Consultation Response from KC, Highways Development Management
2026/91821 975, Leeds Road, Deighton, Huddersfield, HD2 1UP
Change of use from dwelling (Use Class C3) to residential care home (Use Class C2)
Date Responded: 6 August 2026
Responding Officer: Sheila Henley
Responding Ref: 4-11NE/2

Plan ref: 600-706 Existing and Proposed Plans

Proposed Site Plan

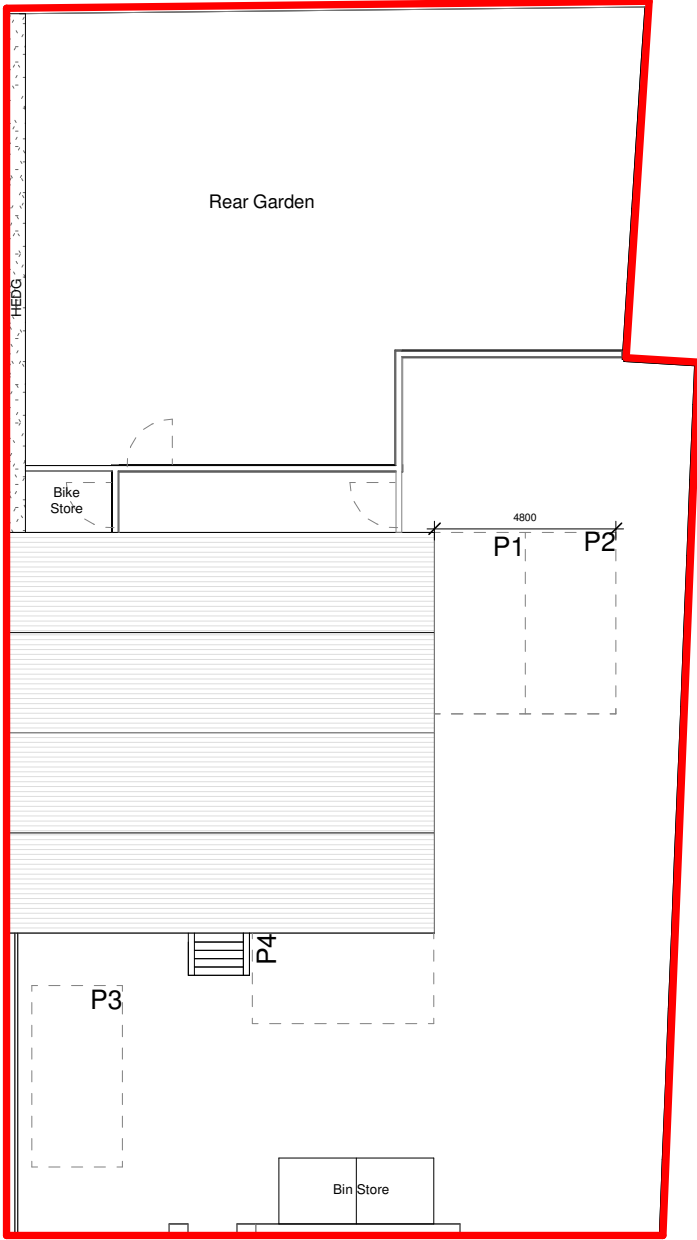
The cycle store would support policy LP20, Active Travel objectives and mode choice. Yet, it is small and likely to be suitable for one bicycle to meet the desired requirements in the KHDG SPD, although preference is for a minimum of two spaces to provide an option for residents and staff. Electric bicycles should be considered too.

An electric vehicle charging point should be installed to help with sustainability and lowering emissions in line with policies LP20 and LP24.

The amount of hardstanding is sufficient to accommodate several cars, including the four specified within the submission. This amount is enough to serve the proposal exceeding the advised minimum amounts typical of C2 use classes of one space per six bedrooms (two spaces), and one space per three staff (one space) to total three spaces for this circumstance. Additionally, the numbers would remain equivalent to the existing provision and exceeding the advice for C3 residential dwellings under the Kirklees Highway Design Guide SPD of three spaces for four plus bedroomed units. The space for parking would offer flexibility to support policy LP22 for the shift changes and regular visits.

Cycle parking and evcp's as above. There is scope to for motor cycle parking too.
